Ribble Valley Borough Council
Development Control

Application no: 3/2019/0484

Address: James Alpe ,Vehicle Repair Lincoln Way , Clitheroe

Proposal: increased workshop and additional car parking

PROPOSED SITE PLAN					
Site: Vehicle Repair Centre - Workshop Extension Lincoln Way Clitheroe					
Client: James Alpe					
Date: 11.07.19	Scale: 1:500 @ A2				
Project No: ALP/21 - Dwg 06a			Drawn: AxK		
Amendments:	A

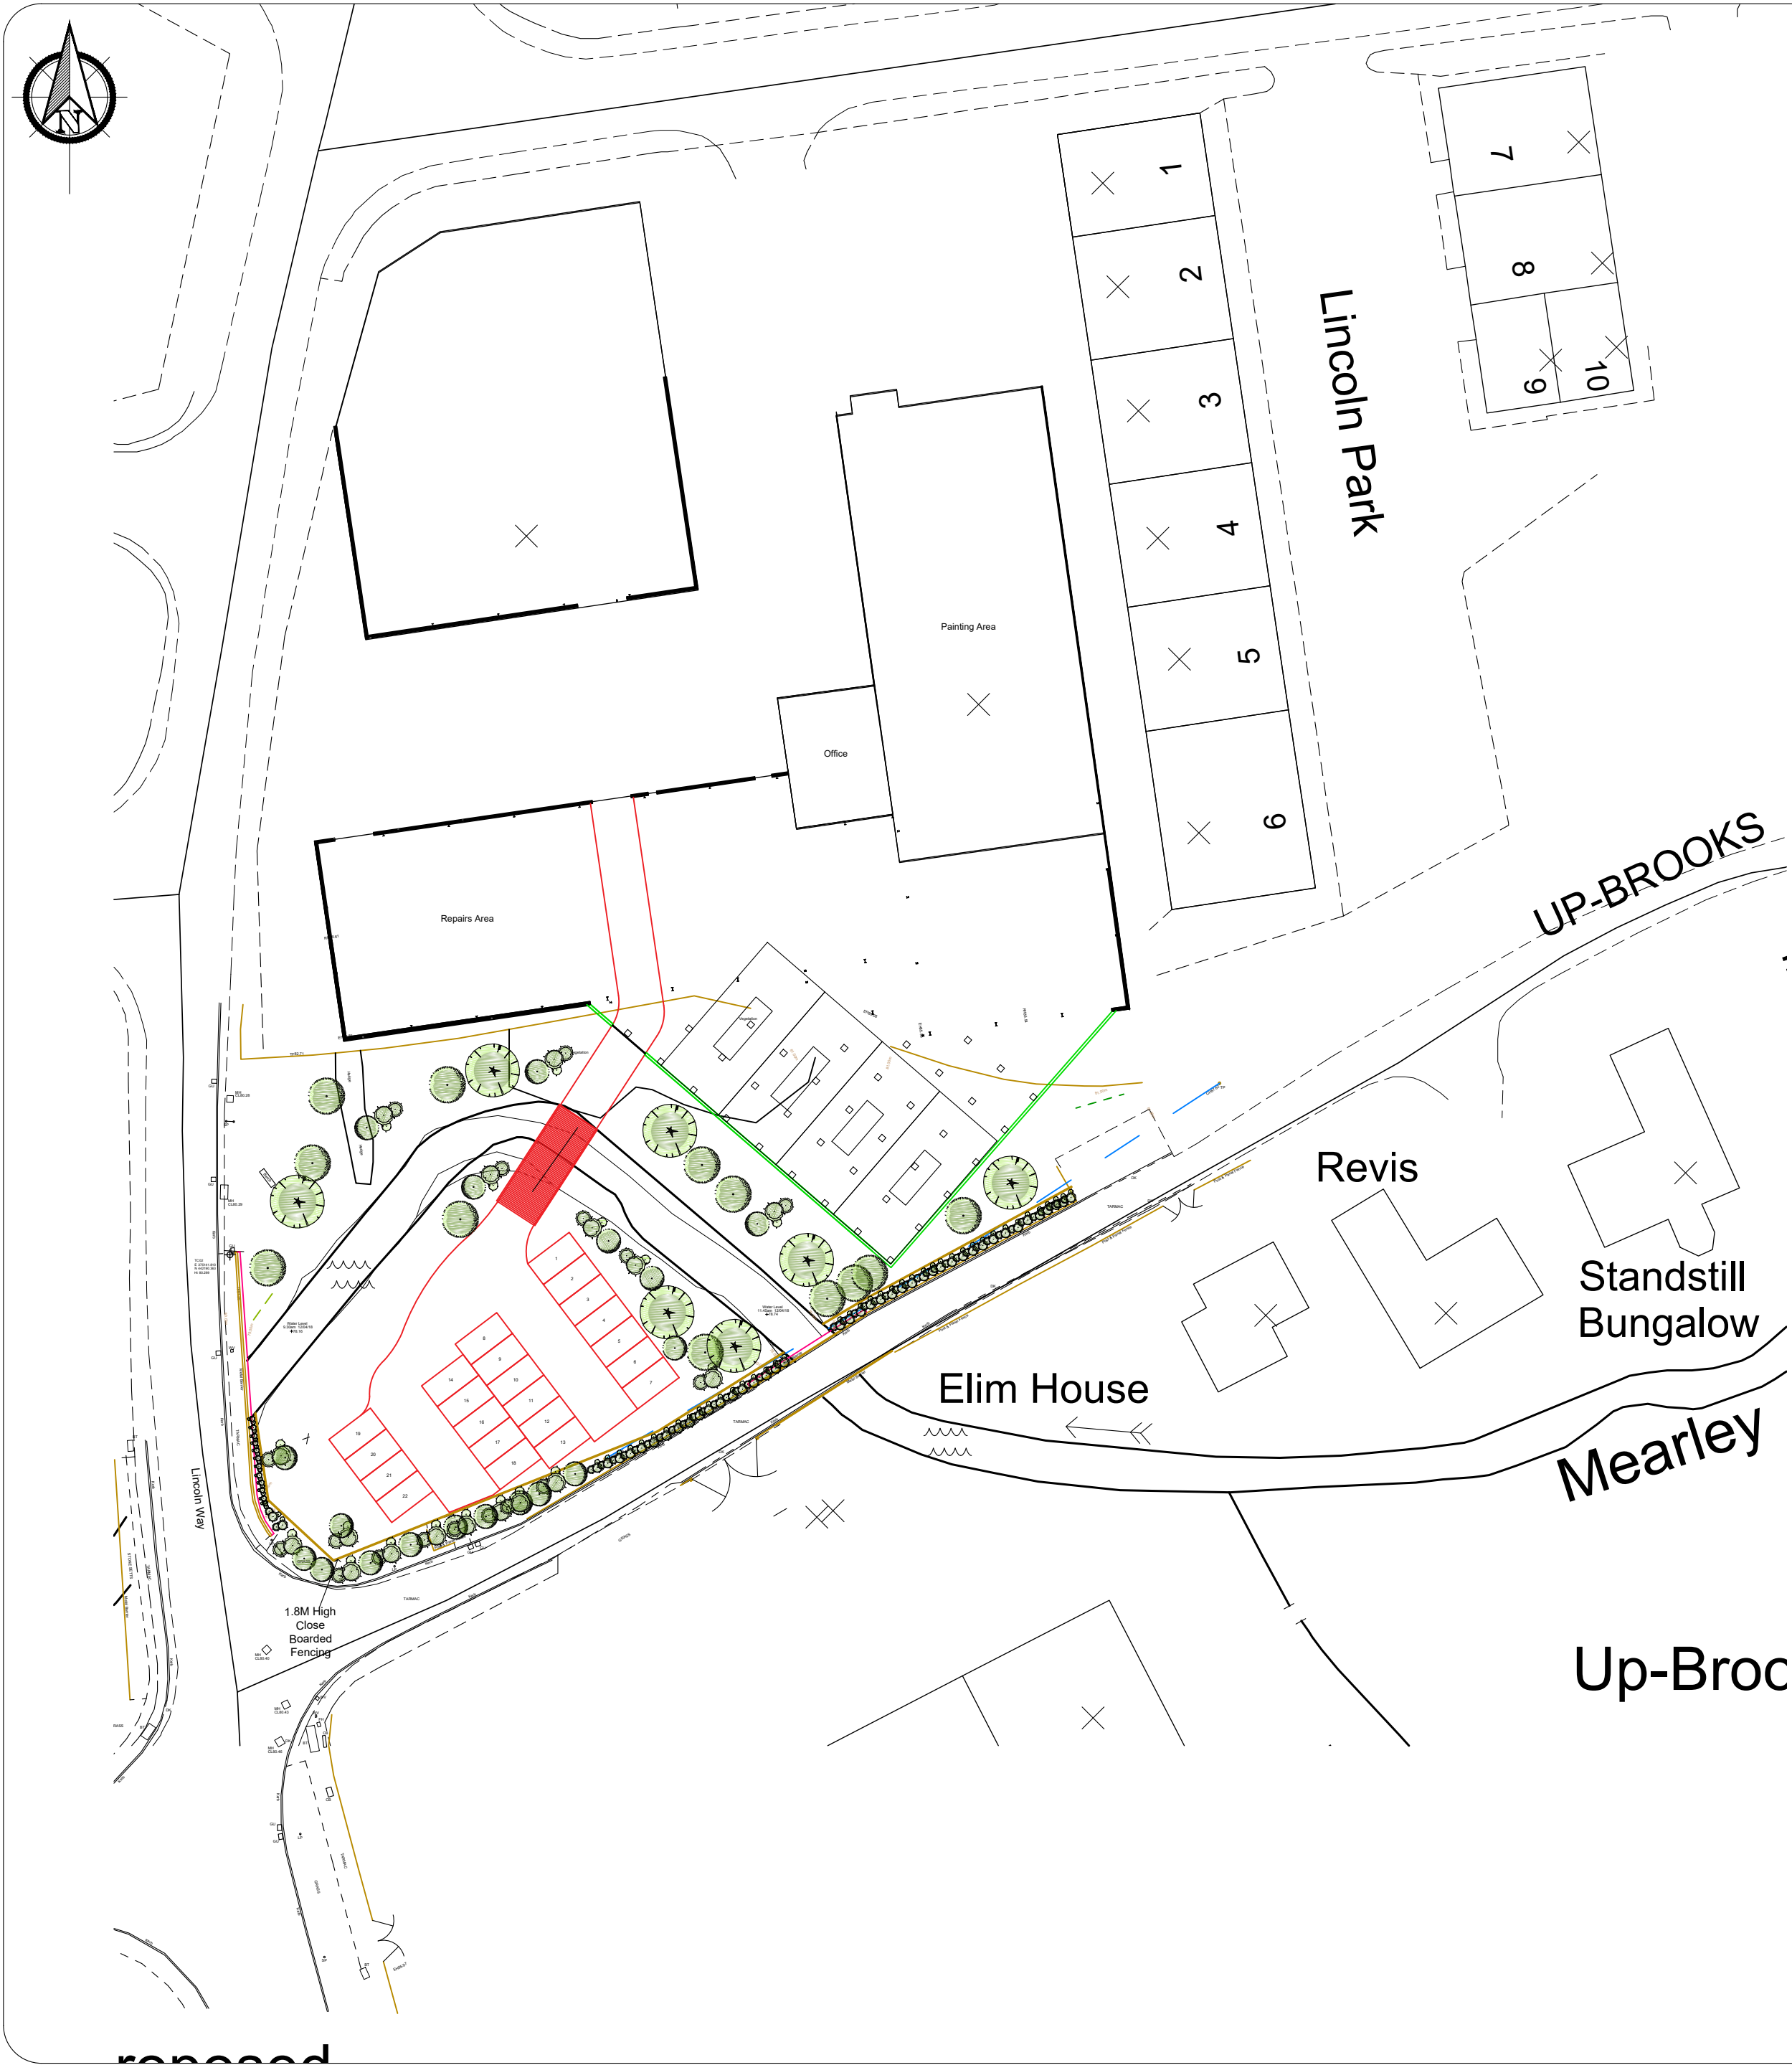
The proposal will increase the size of this facility which will be offset by the additional parking proposed and in this respect I would raise no objection to the proposal, however there are existing issues of on street parking between the entrance to the site and Lincoln Way and in this respect the development will increase vehicular traffic through this junction. In order to counter this and improve traffic flows and visibility I would like to see additional waiting restrictions introduced in this area and therefor would request that should your council be minded to approve this application the following conditions be attached to any permission that may be granted

1. The car park shall be surfaced or paved in accordance with a scheme to be approved by the Local Planning Authority and the car parking spaces and manoeuvring areas marked out in accordance with the approved plan, before the use of the premises hereby permitted becomes operative. Reason: To allow for the effective use of the parking areas.
2. There shall be no direct pedestrian or vehicular access between the site and Lincoln Way / Up Brooks and to that end a continuous wall or fence not less than 1.8m in height shall be erected before development commences and be permanently maintained on the highway boundary of Lincoln Way and Up Brooks all vehicular and pedestrian access being obtained from the main site entrance. Reason: To limit the number of access points to the highway network aiding road safety and site security.
